<b>Application Ref:</b>	3/2025/0536			 Ribble Valley Borough Council <small>www.ribbonvalley.gov.uk</small>
<b>Date Inspected:</b>	28/08/2025	<b>Site Notice:</b>	N/A	
<b>Officer:</b>	MC			
<b>DELEGATED ITEM FILE REPORT:</b>				<b>APPROVAL</b>

<b>Development Description:</b>	Part retrospective outline planning permission to demolish the existing bungalow and proposed new detached self-build 4/5 bedroom house with access applied for (all other matters reserved).
<b>Site Address/Location:</b>	Dale Hey Bungalow, Preston Road, Ribchester, PR3 3XL

Dwmg No. A4578-PL04 Rev. A

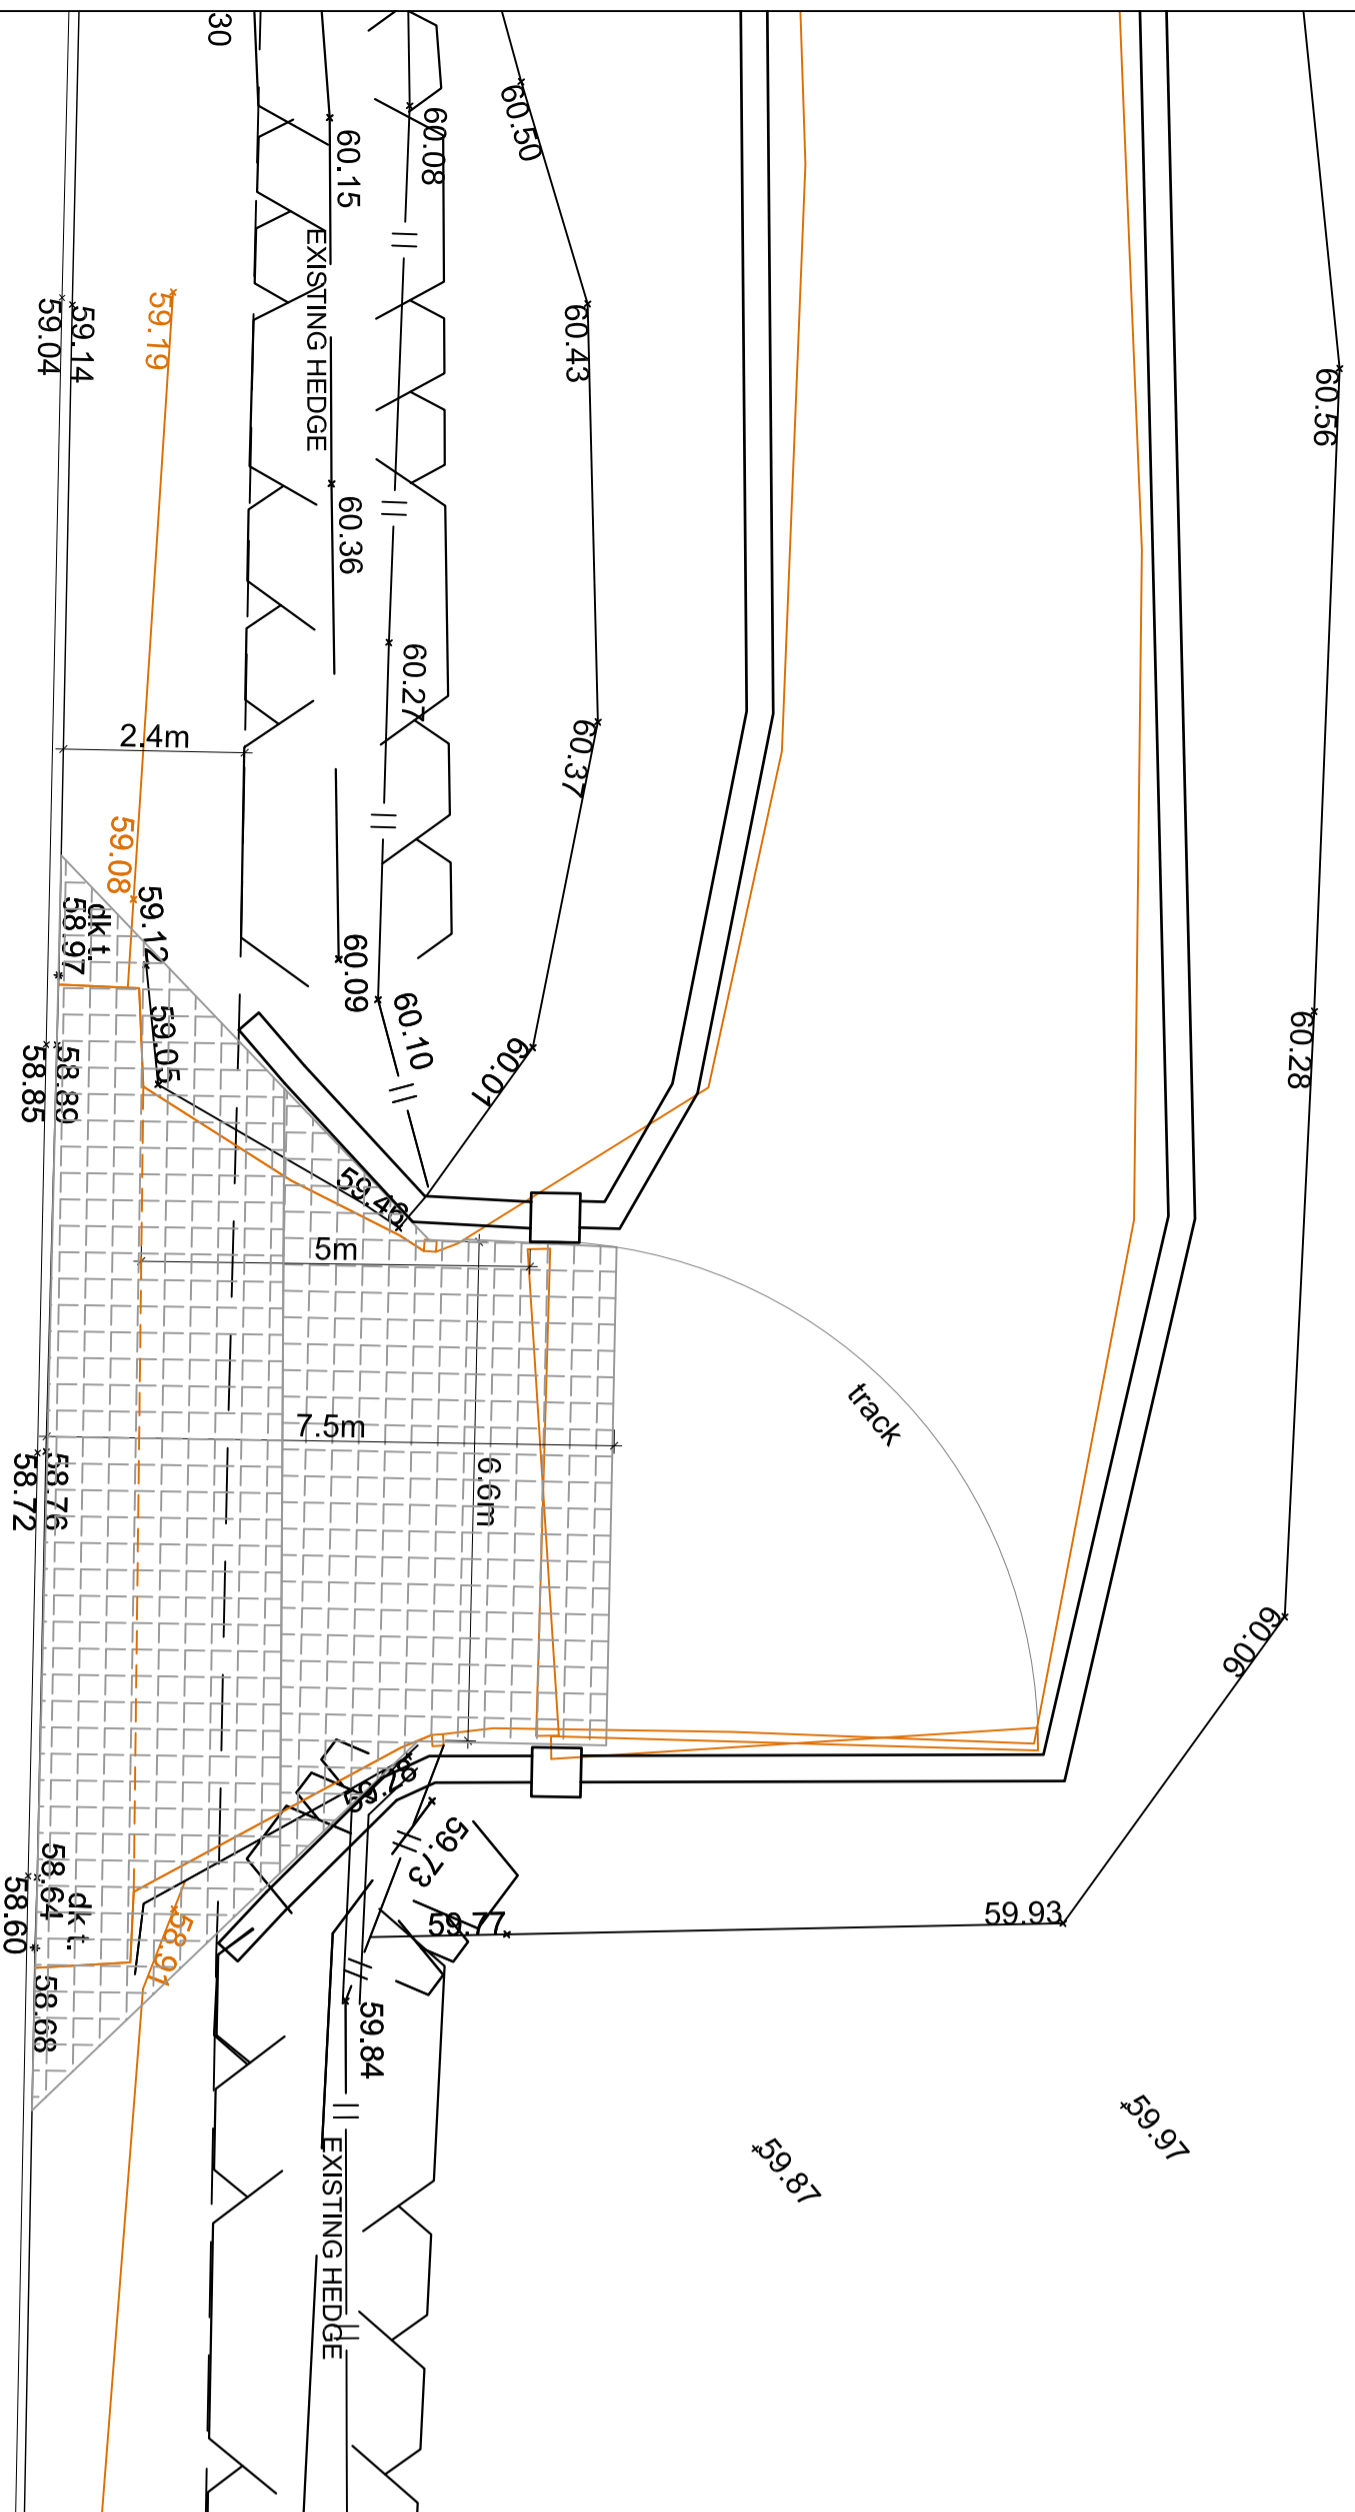
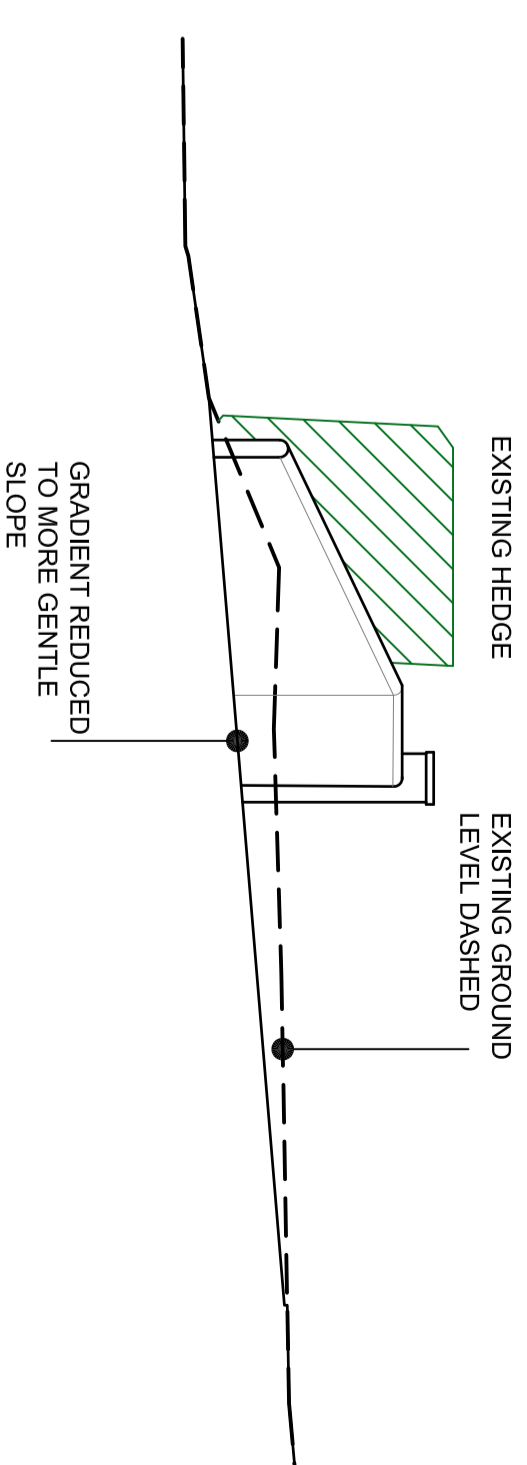
The proposed access as indicated on the drawing shows walls at the site access extending from 1m in height at the road side to 2.4 metres approximately further within the site. As this relates to boundary treatments this would be a matter to be considered at reserved matters stage when landscaping is applied for. In principle however this is not considered to be out of keeping with the character of the surrounding area, where there are stone walls running parallel to the road at Dale Hey Touring Park. The stone walling would only be 1.1 in height closest to the road and the land levels would be slightly reduces to create a more gentle slope. Such works are not considered to result in any significant detrimental harm to the character and appearance of the open countryside, given the presence of similar boundary treatments within the vicinity of the site.
